From: Laura Gibbons
Sent: 07 September 2018 15:16
To: Planning.Responses
Cc: Zac Denton
Subject: RE: Planning Consultation on: WA/65/18/HH

Engineers Comments Regarding Surface Water Drainage

APPLICATION WA/65/18/HH

2018
Site Address: Richmond House Arundel Road Walberton BN18 0QP
Grid Reference: 495786 106902
Description of Works: Retention of double garage & with new layout to screening to the North West highway boundary.

NEW PLANTING AT NORTH SIDE OF PROPERTY FRONTING ARUNDEL ROAD 1/125

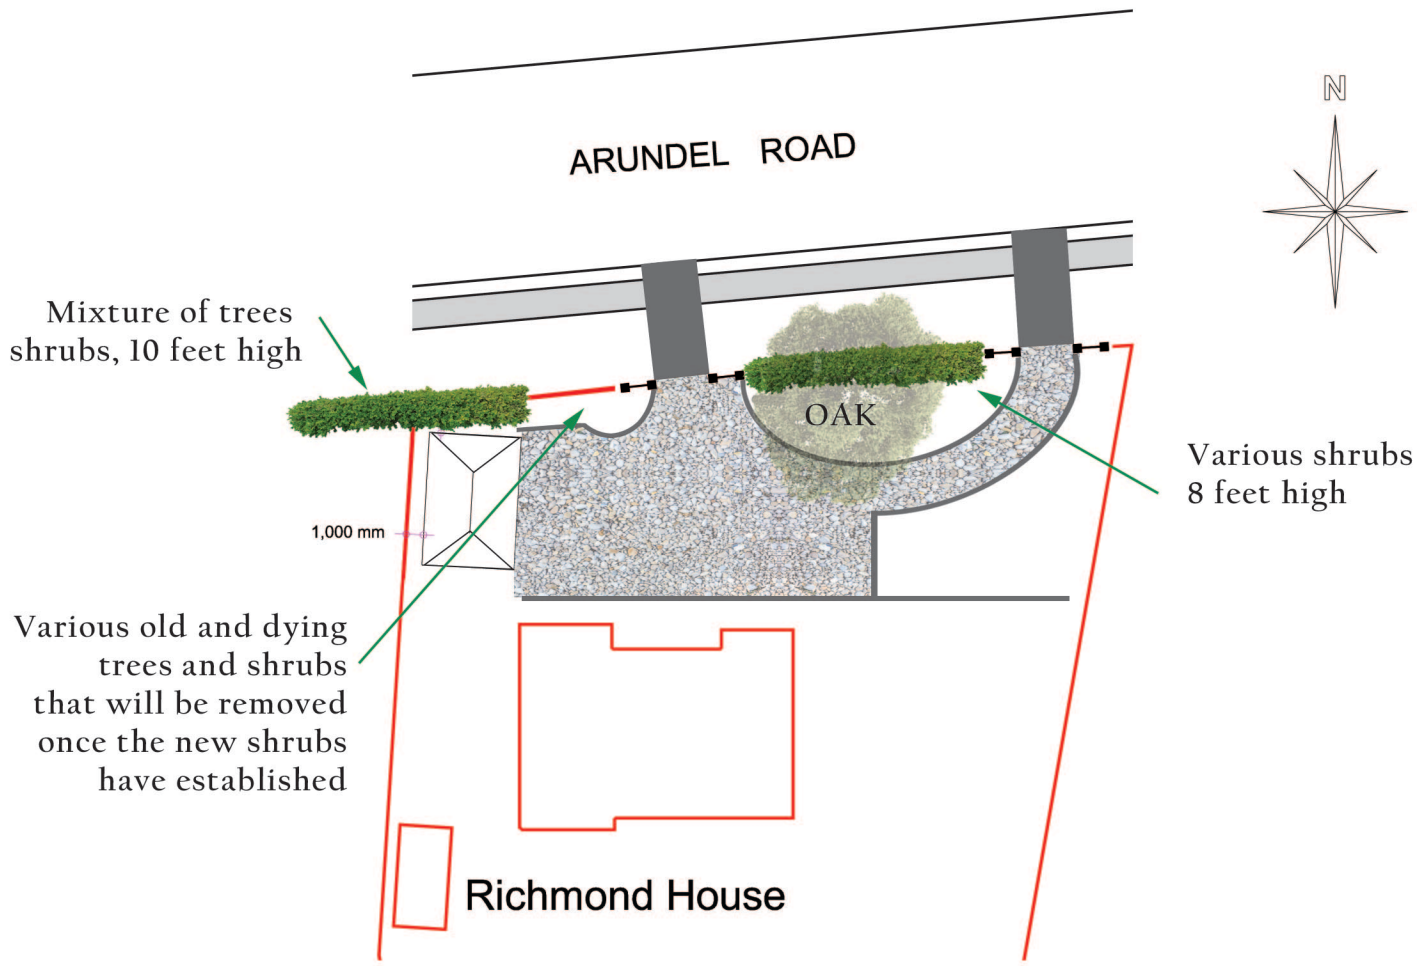
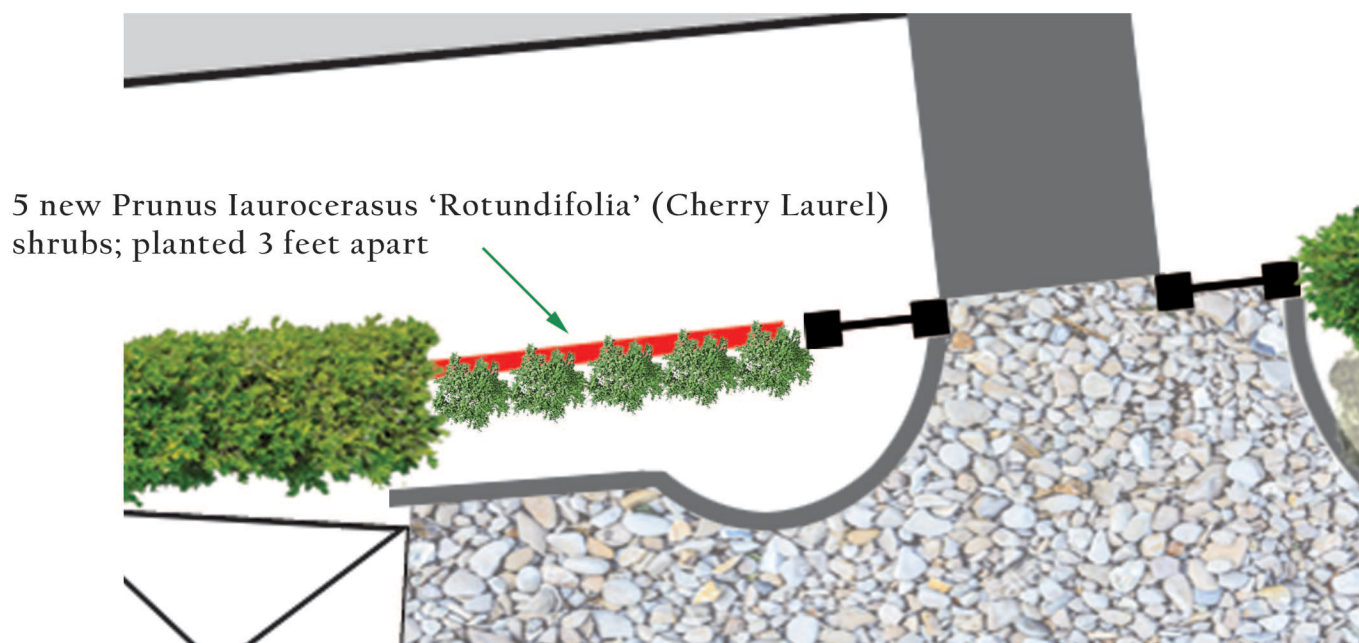
The application is for the alteration to planting. A comment has been provided stating concerns about the effect of the proposals on surface and sub surface flows.

The proposals are to replace existing dying plants with a new laurel hedge. This shouldn't have a negative impact upon flows. The new growth should provide more interception.
